Application by Highways England for an Order Granting Development Consent for the A38 Derby Junctions Scheme
The Examining Authority's first written questions and requests for information
Issued on Friday 11 October 2019.

The following table sets out the Examining Authority's written questions and requests for information to assist with the assessment of the application.

Figure 4b: ARN for Operation Phase- Change in Road Alignment

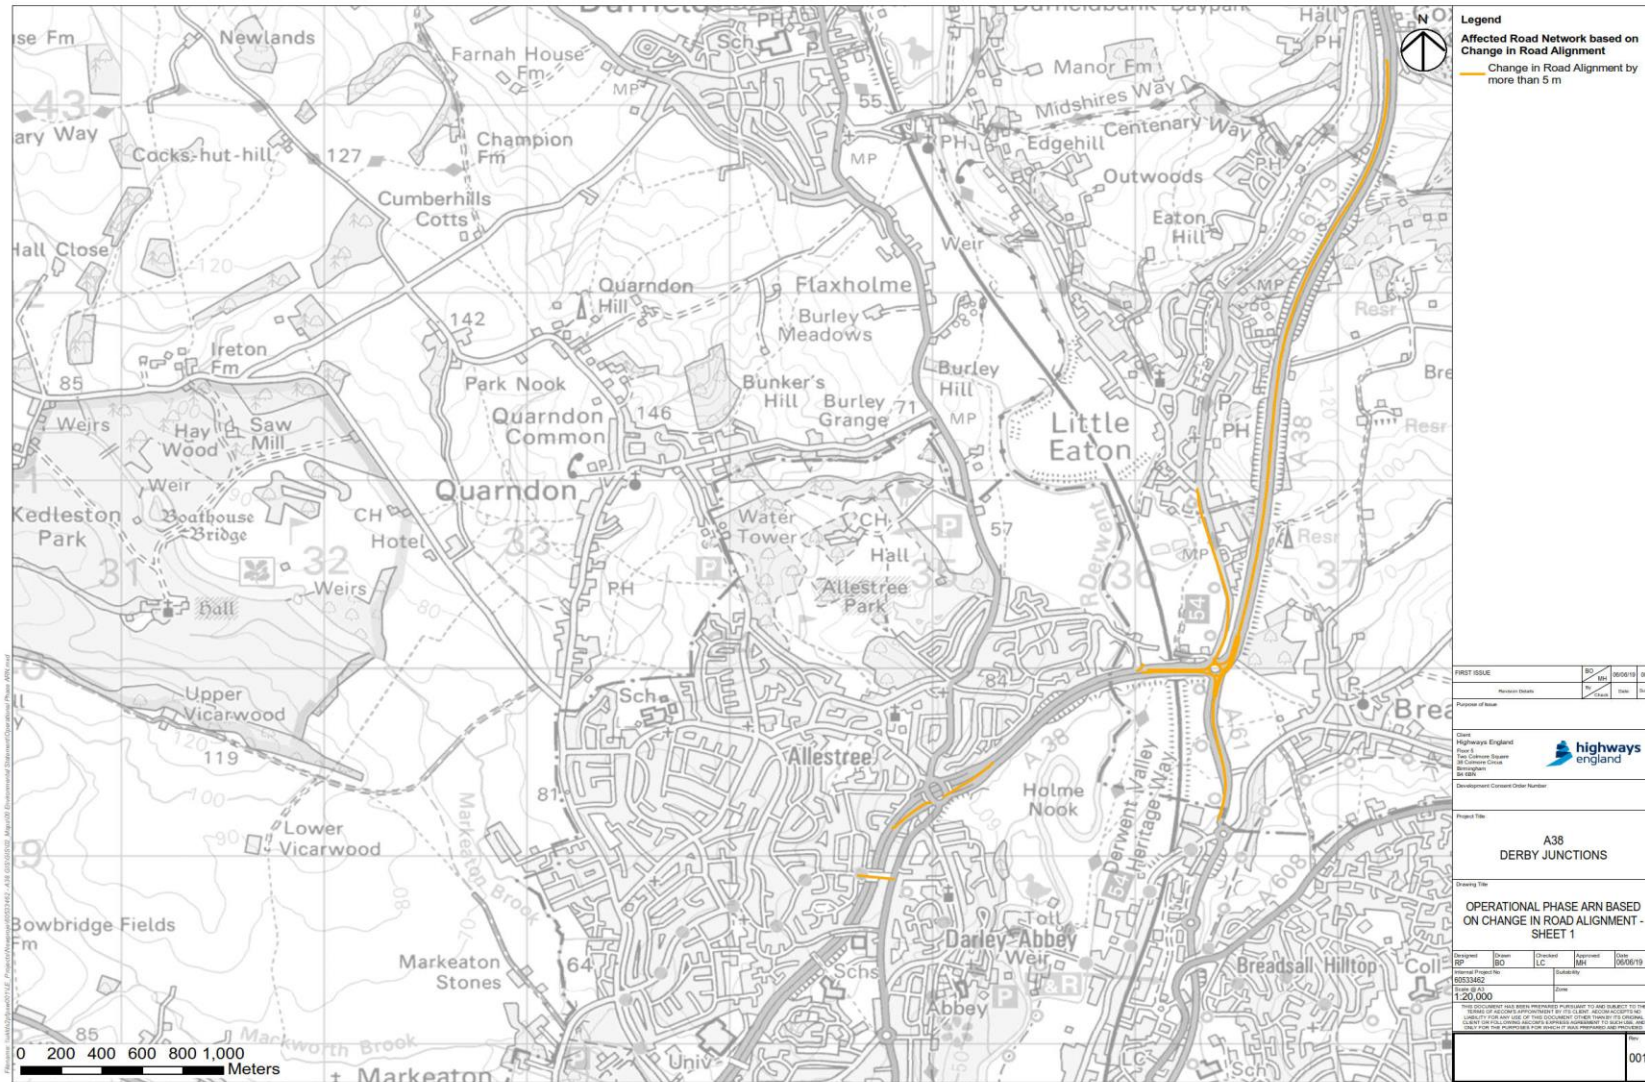
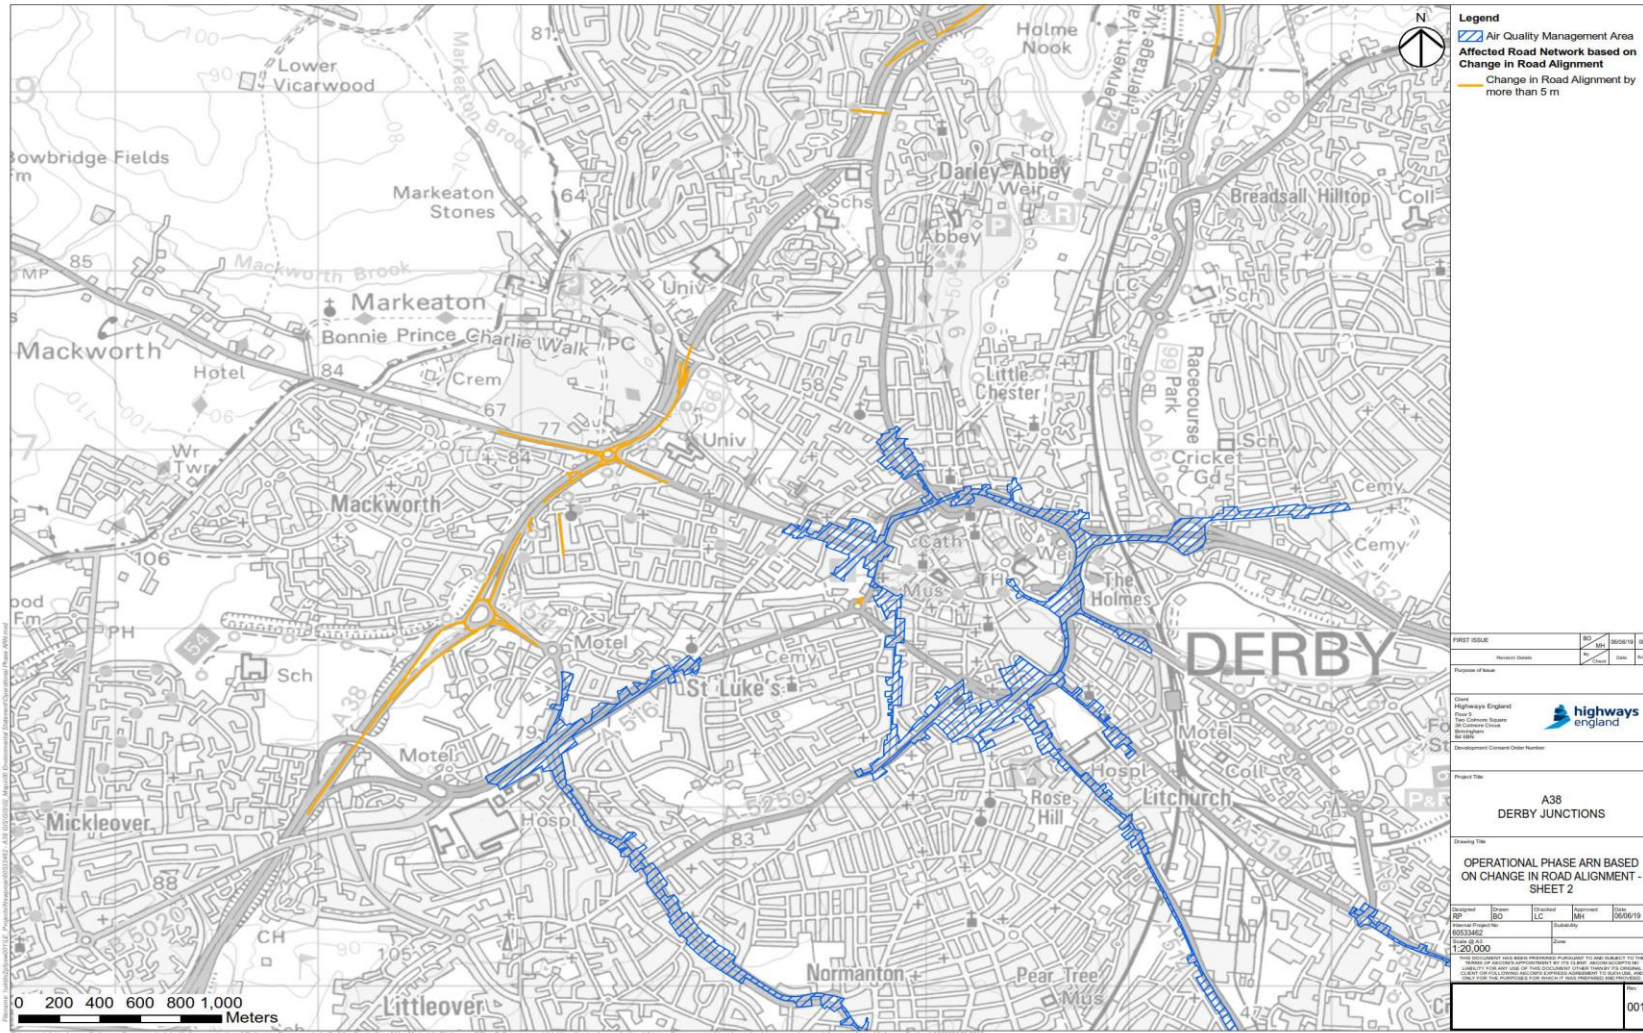
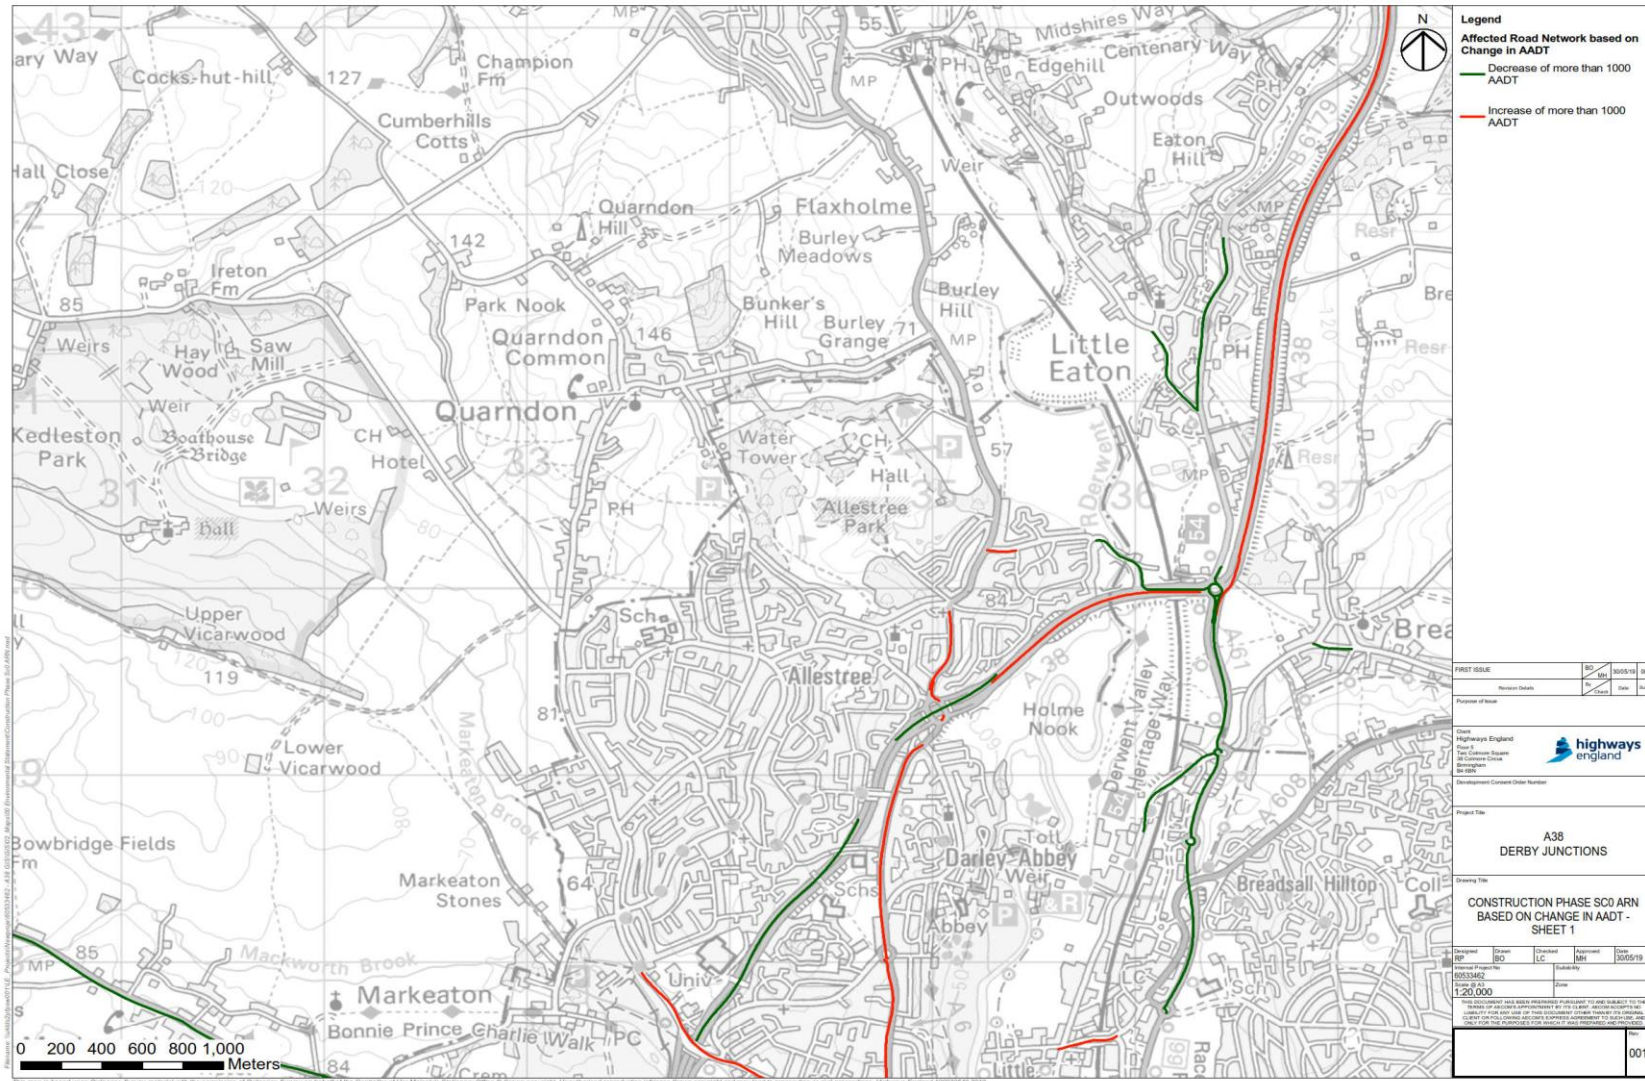
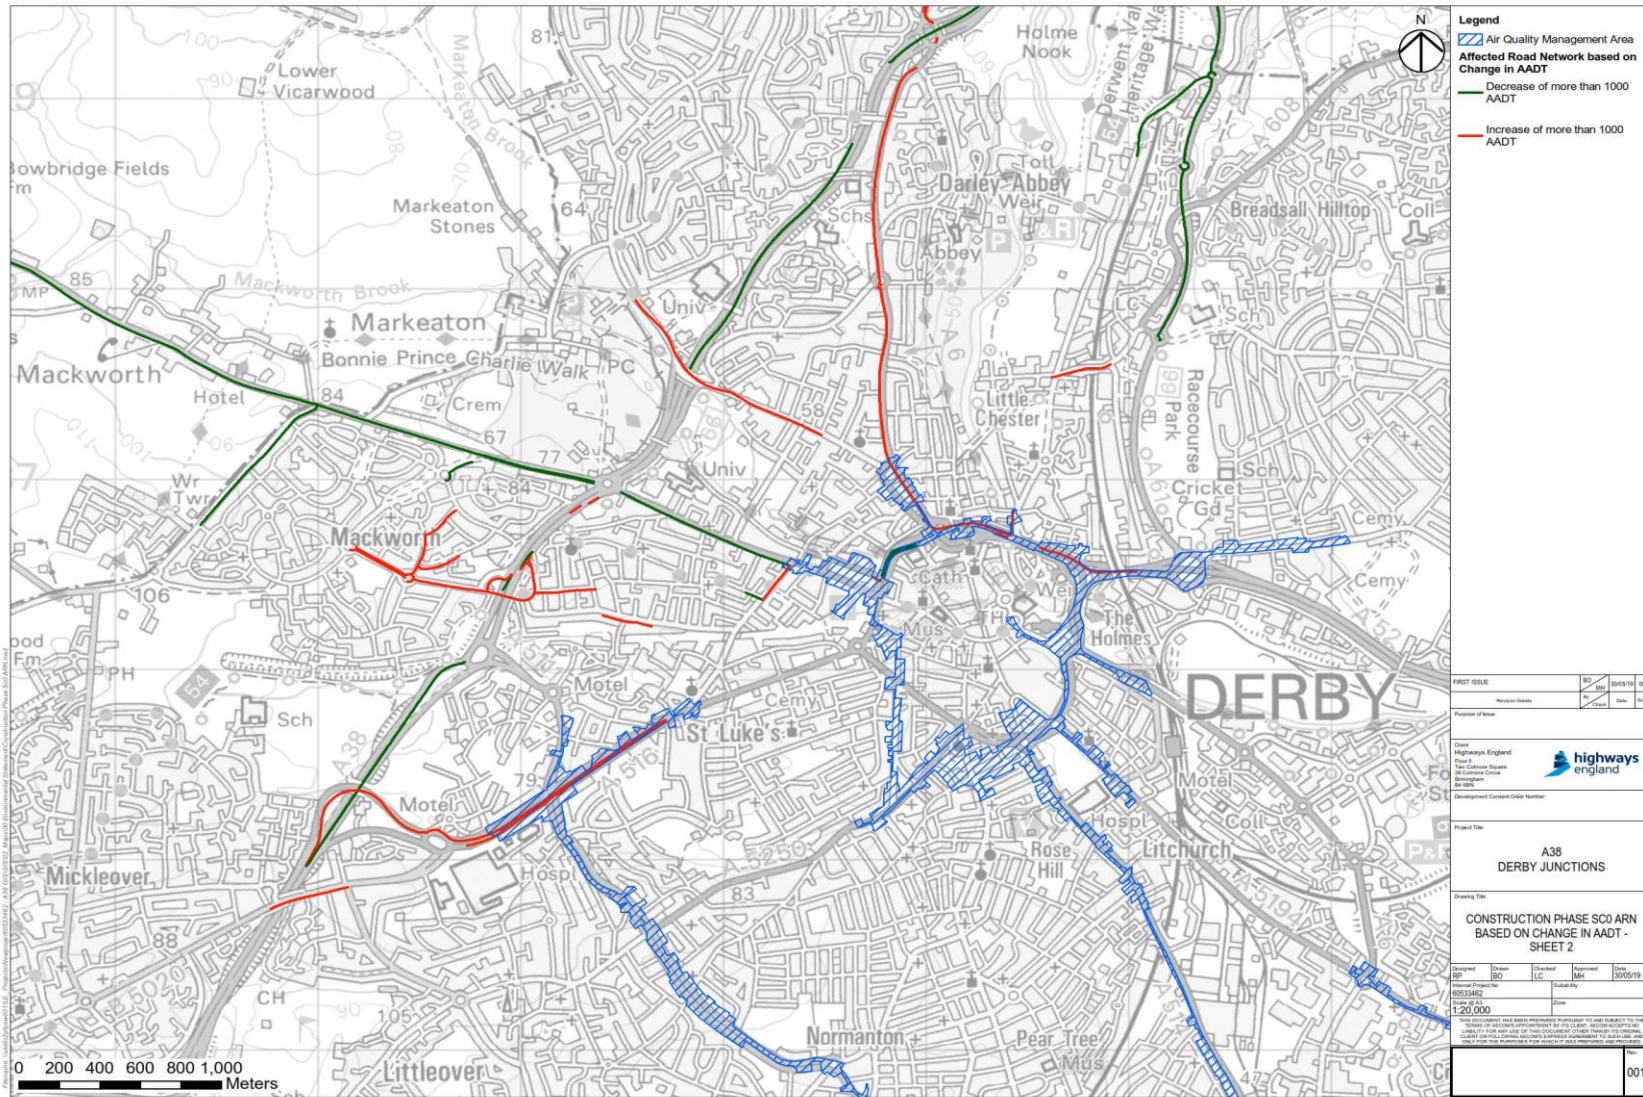
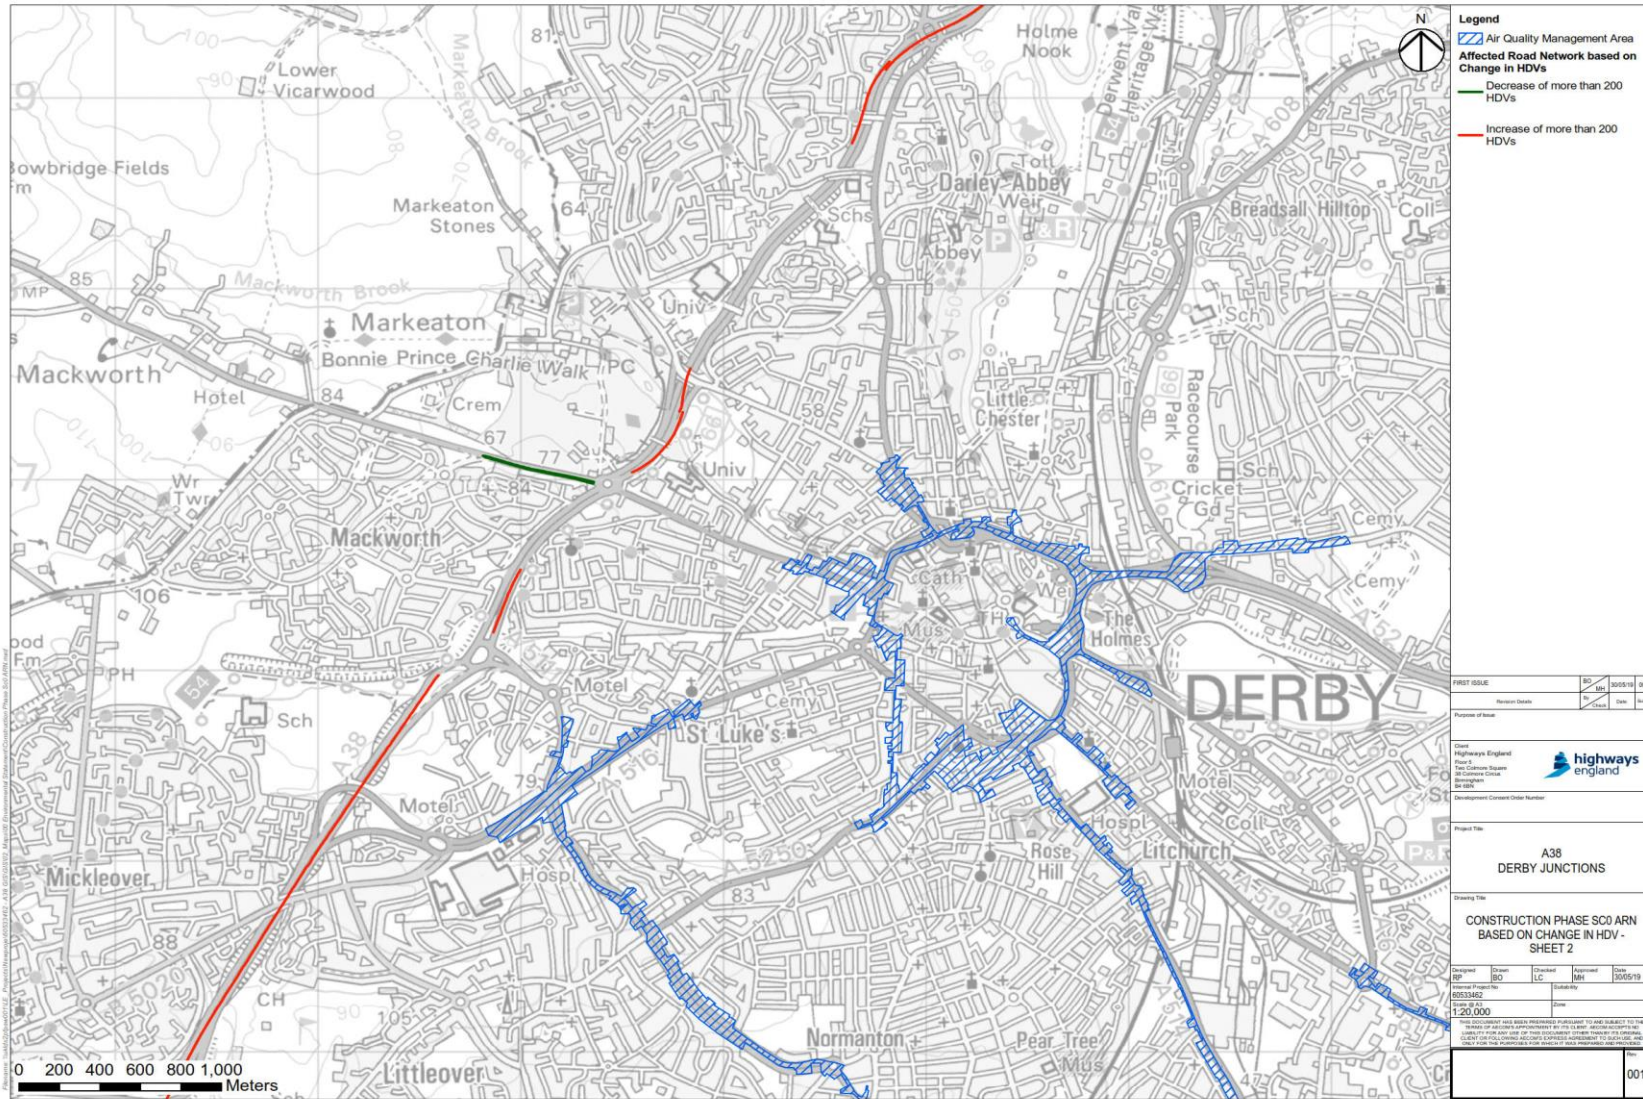
5. Air quality			
Baseline conditions and overall assessment methodology			
5.1.	Applicant	Details of exceedances of air quality screening criteria at affected road links.	The Applicant was issued with s51 advice on 22 May 2019 requesting further information regarding the screening process for inclusion of receptors/road links on the affected road network for further consideration in the assessment. In its response [AS-013] the

No	Question to	Reference	Question
			<p>Applicant provided updated figures [AS-006] to illustrate affected road links. However, detailed information demonstrating how the air quality screening criteria are exceeded were not supplied.</p> <p>Please provide specific details of how the affected road links exceed the DMRB screening criteria during both construction and operation or signpost to where this may be found in the application documents.</p>
